**From:** Contact Centre (CRM) <contact@ribblevalley.gov.uk>  
**Sent:** 25 June 2024 11:48  
**To:** Planning  
**Subject:** Planning Application Comments - 3/2024/0431 FS-Case-625606368

**Planning Application Reference No.:** 3/2024/0431

**Address of Development:** 61 Salthill Road  
Clitheroe  
BB7 1PE

PROPOSED FRONT ELEVATION

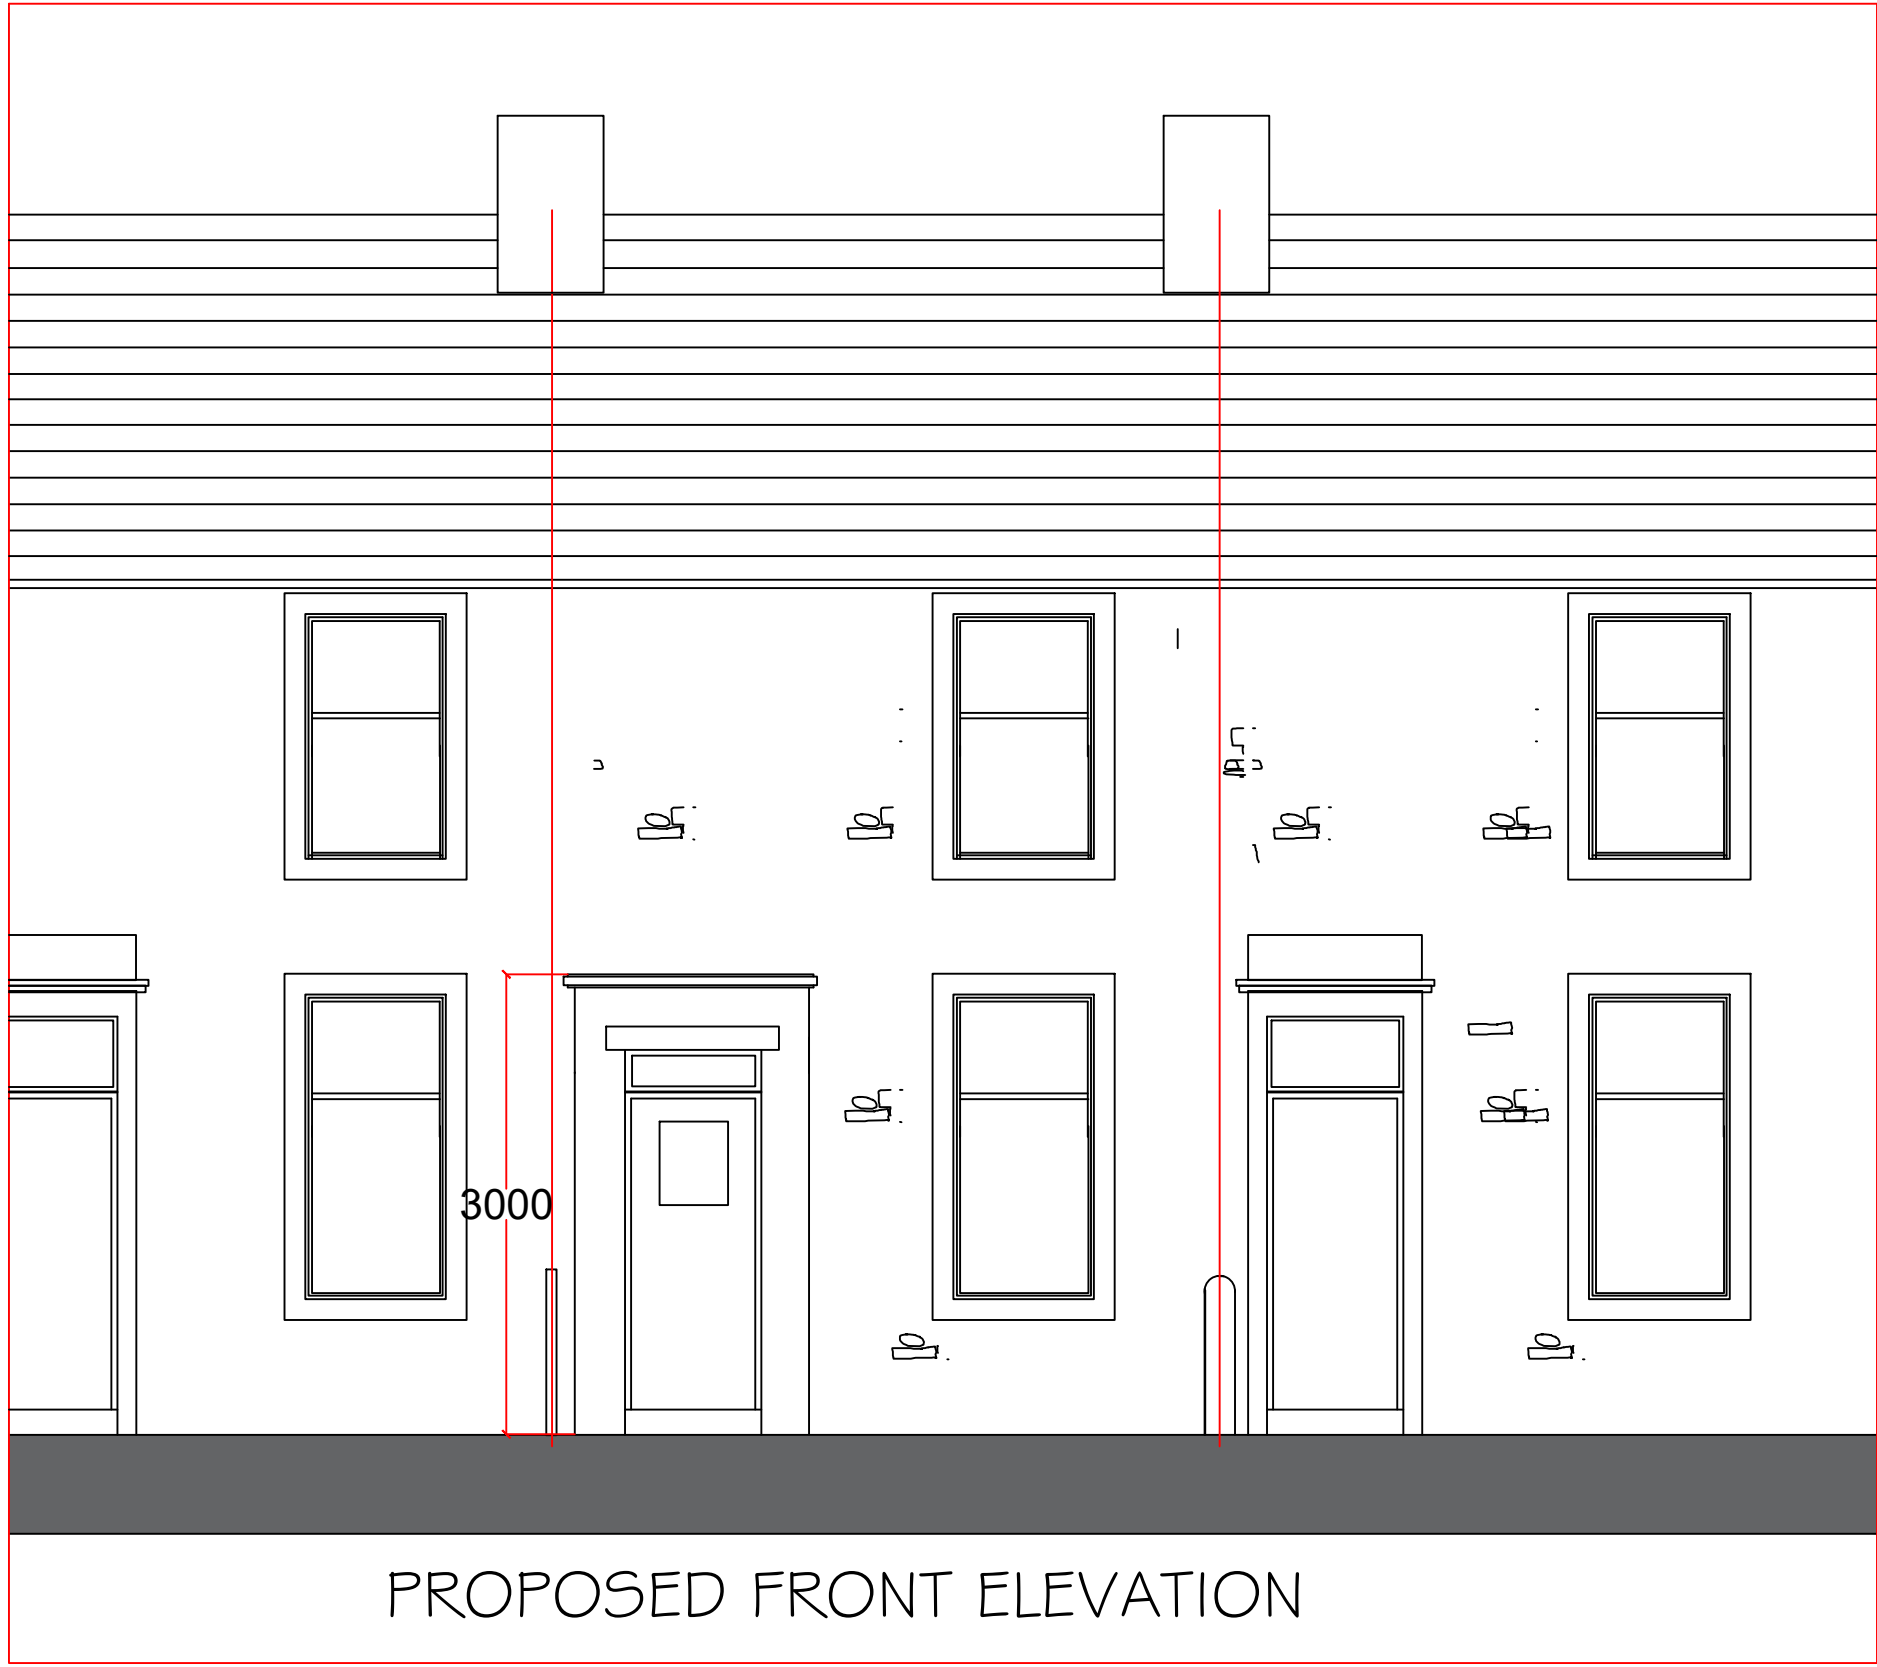
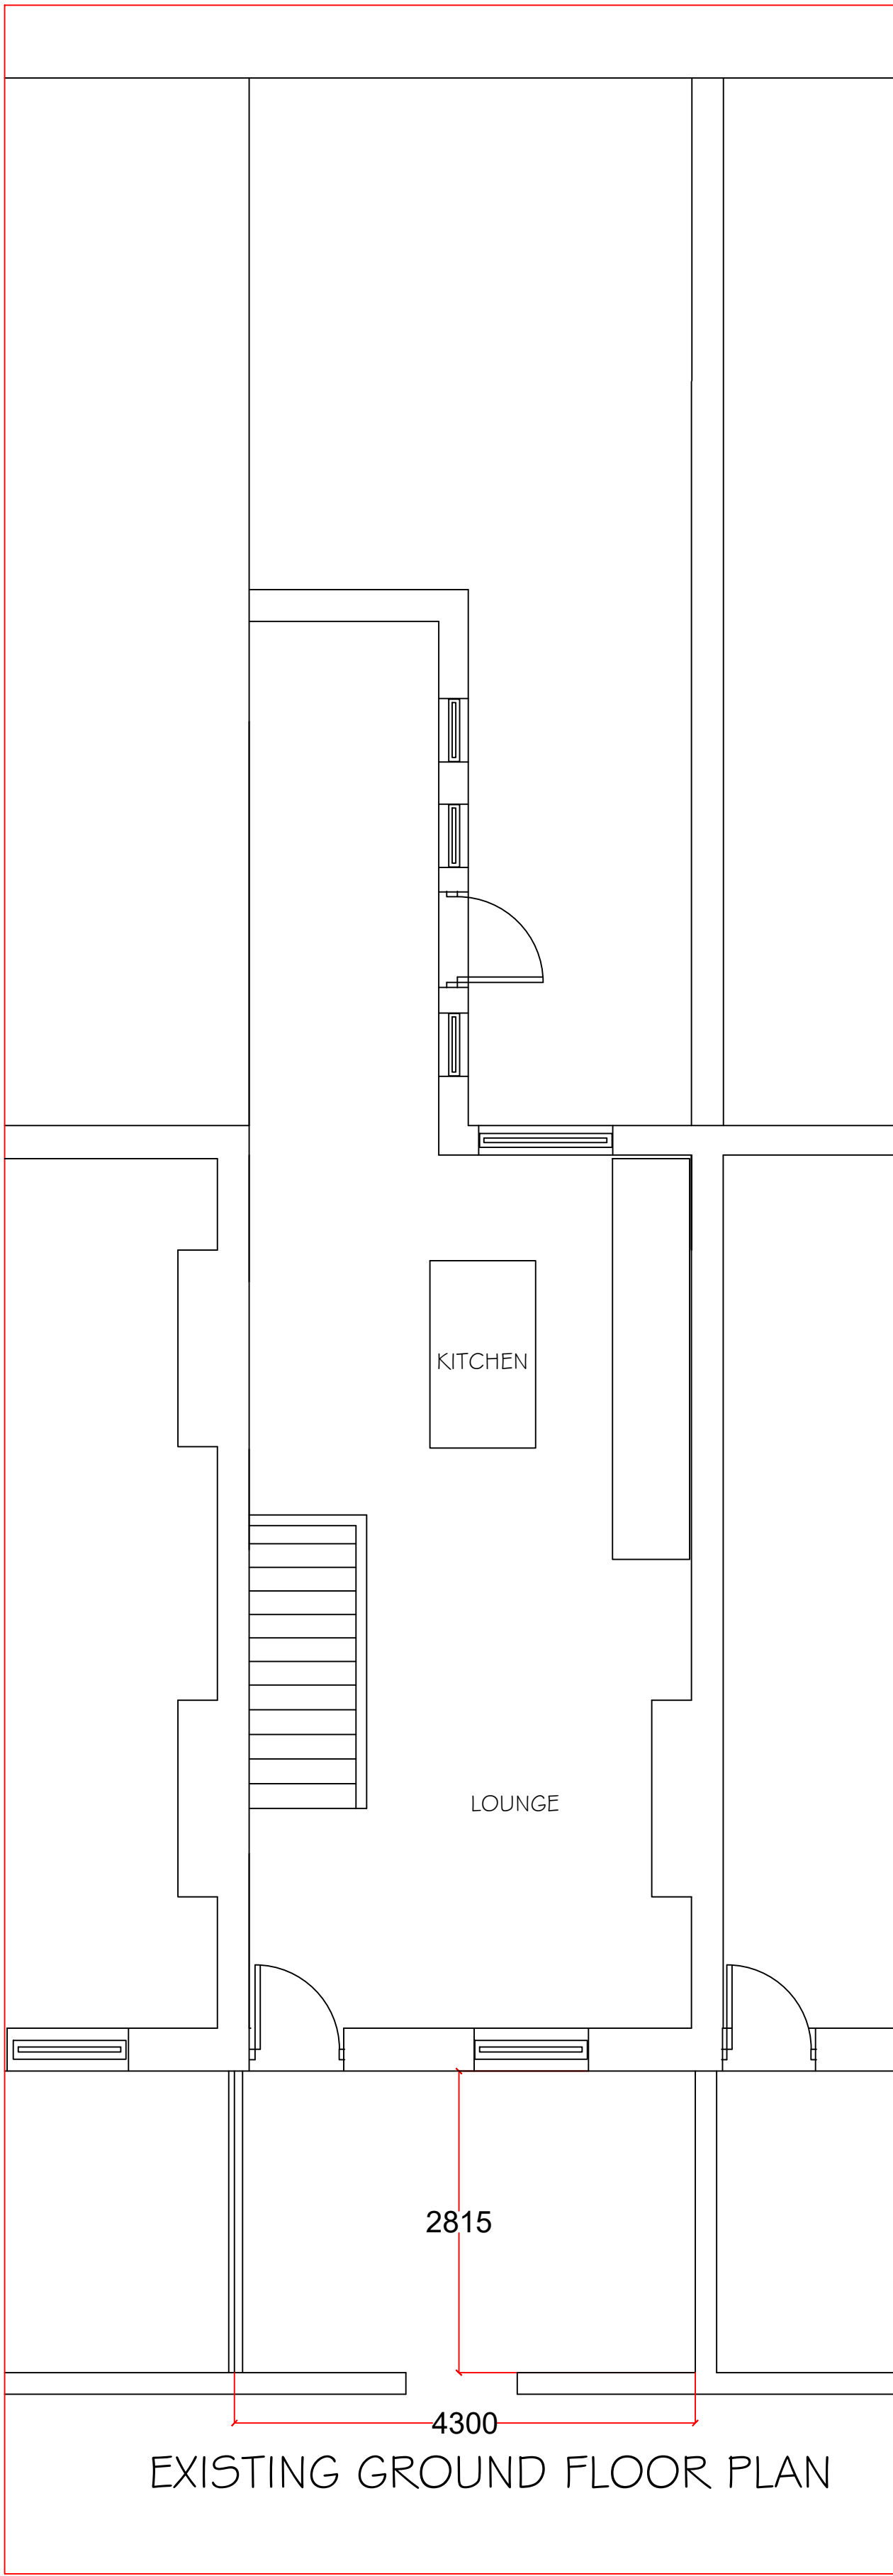
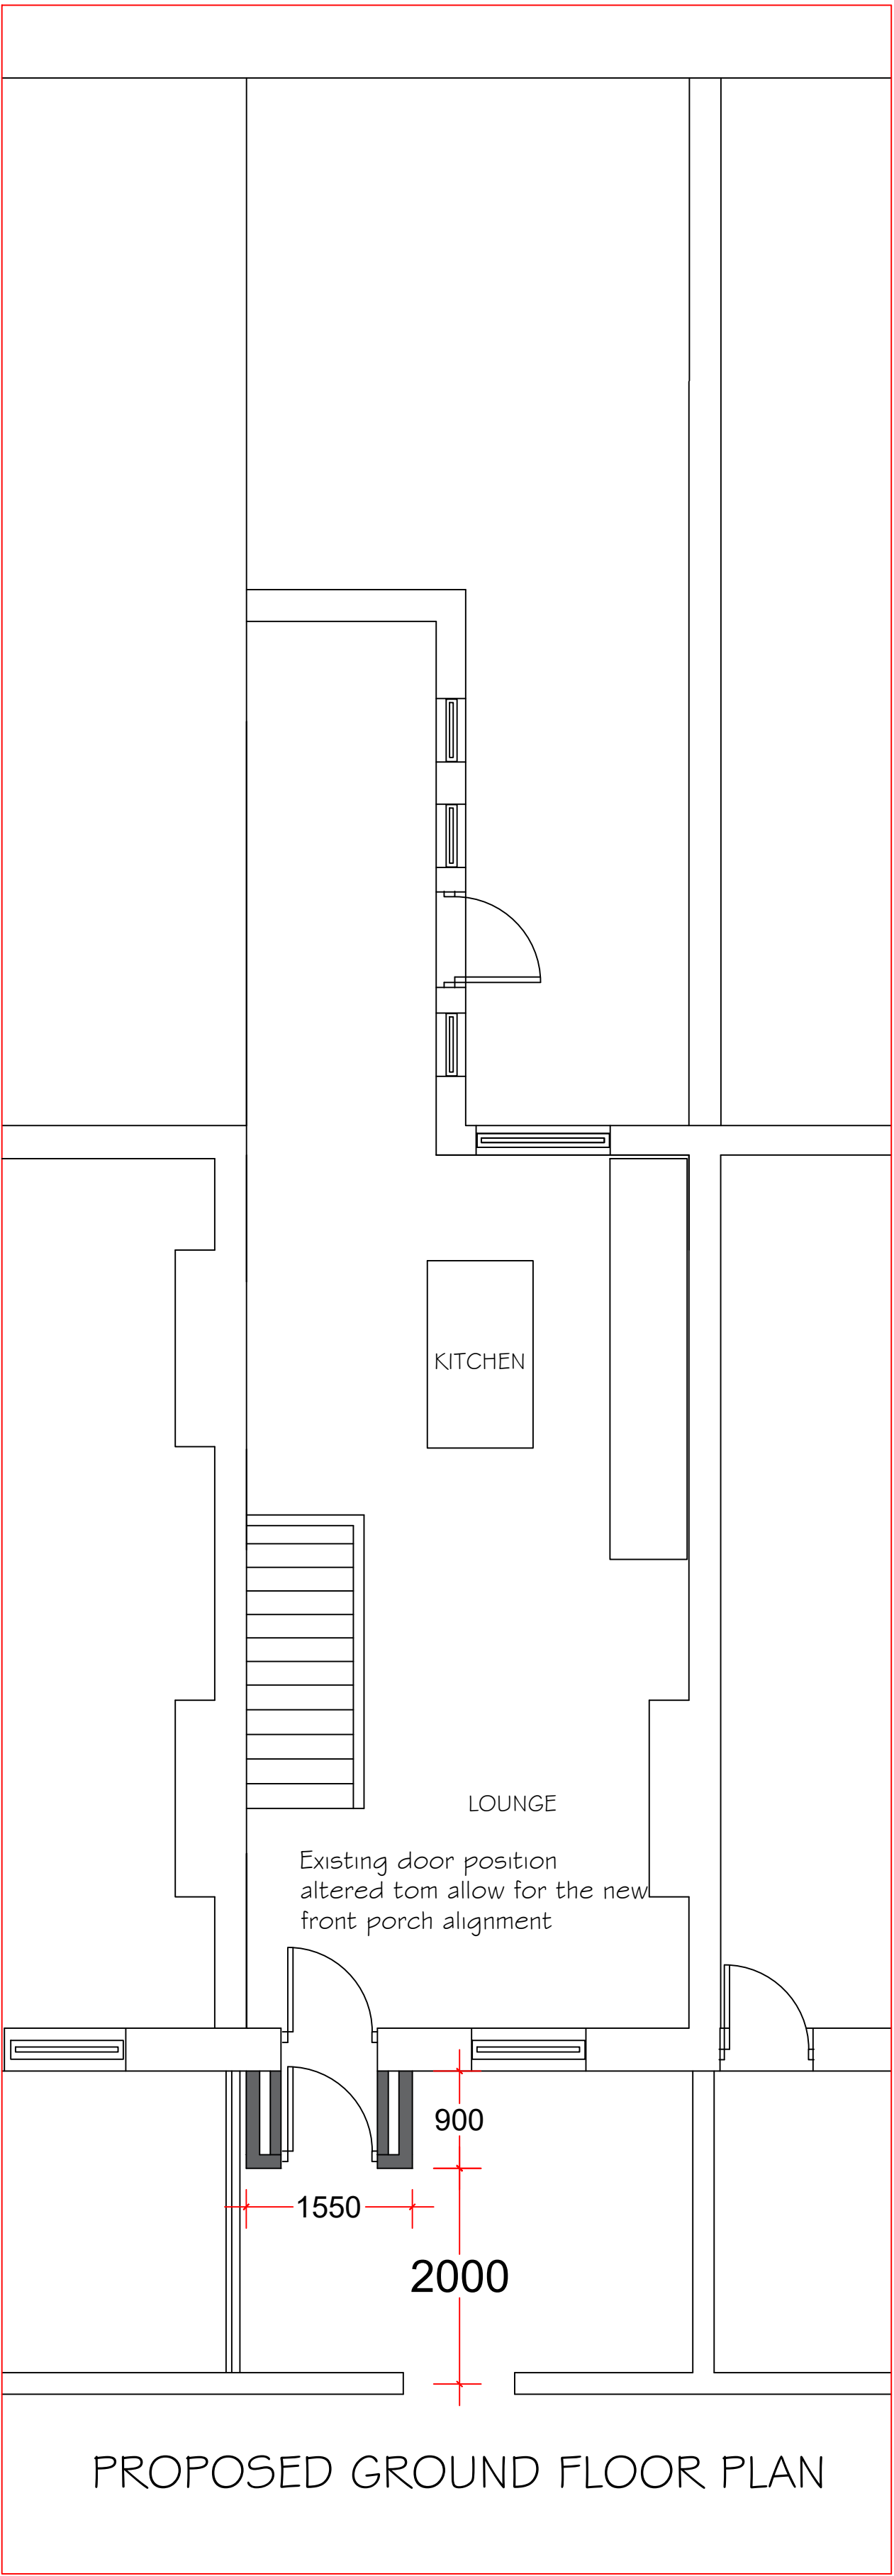
1. The proposed plans would require moving the stone lintel above the doorway(which is [REDACTED] [REDACTED]) and slabs around the door way which is [REDACTED]
2. The porch would be built on the inside of the [REDACTED] which in the future if any work would needed to be carried out, the wall would not be accessible from the side of the neighbouring property [REDACTED].
3. No other property on the street has a porch and I feel this would not be in the upkeeping of the street and furthermore the stone being used aesthetically does not match the street in anyway.
4. I often [REDACTED]. I feel this porch would restrict the light [REDACTED]  
[REDACTED]
